Comment for planning application 23/00376/F

Application Number	<input type="text" value="23/00376/F"/>
Location	<input type="text" value="Land Adjoining And West Of Stonecroft House Clifton Road Deddington"/>
Proposal	<input type="text" value="Erection of 5 single storey age restricted dwellings for older people (60 years) with access, landscaping and associated infrastructure"/>
Case Officer	<input type="text" value="Imogen Hopkin"/>
Organisation Name	<input type="text" value=""/>
Organisation Name	<input type="text" value="JOHN MINSHAW"/>
Address	<input type="text" value="Castle Barns, Castle Street, Deddington, Banbury, OX15 0TE"/>
Type of Comment	<input type="text" value="Objection"/>
Type	<input type="text" value="neighbour"/>
Comments	<input type="text" value="We live in the adjacent property.

Plot 3  
Ground Floor Plan

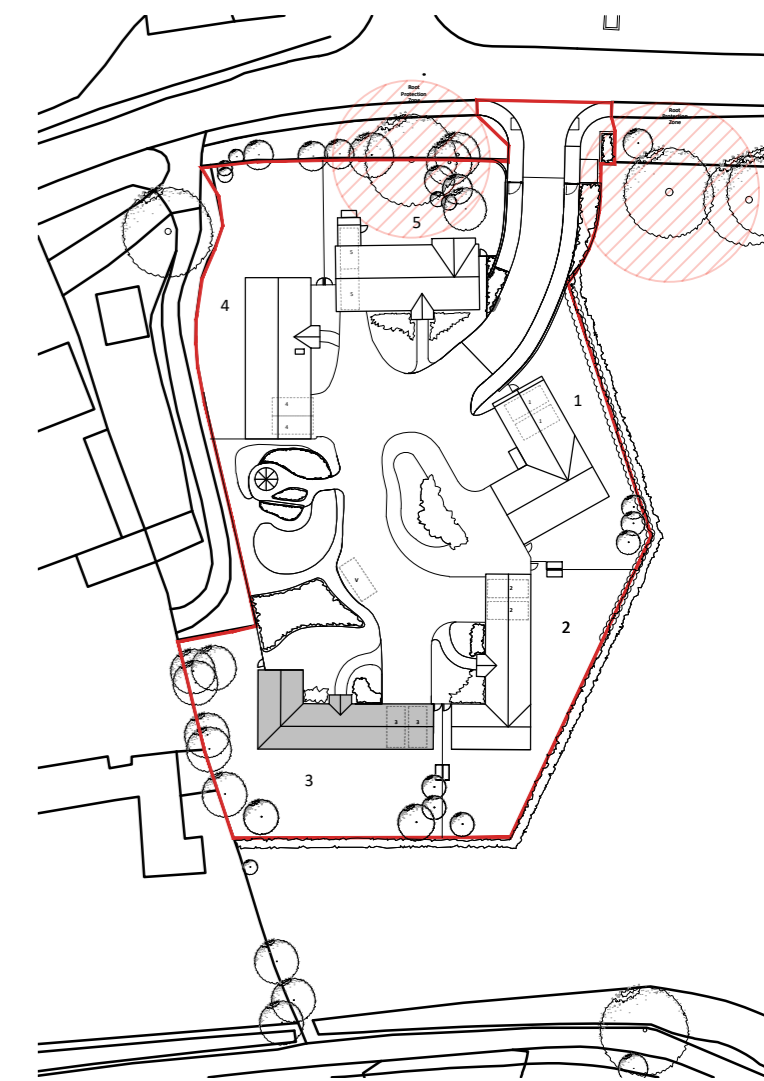
Compared to the previous permitted applications the new application is considerably closer in proximity to our boundary line. This impacts privacy, visibility and noise. Plot 3 for example now impinges on our property and has a direct view into our main living space.
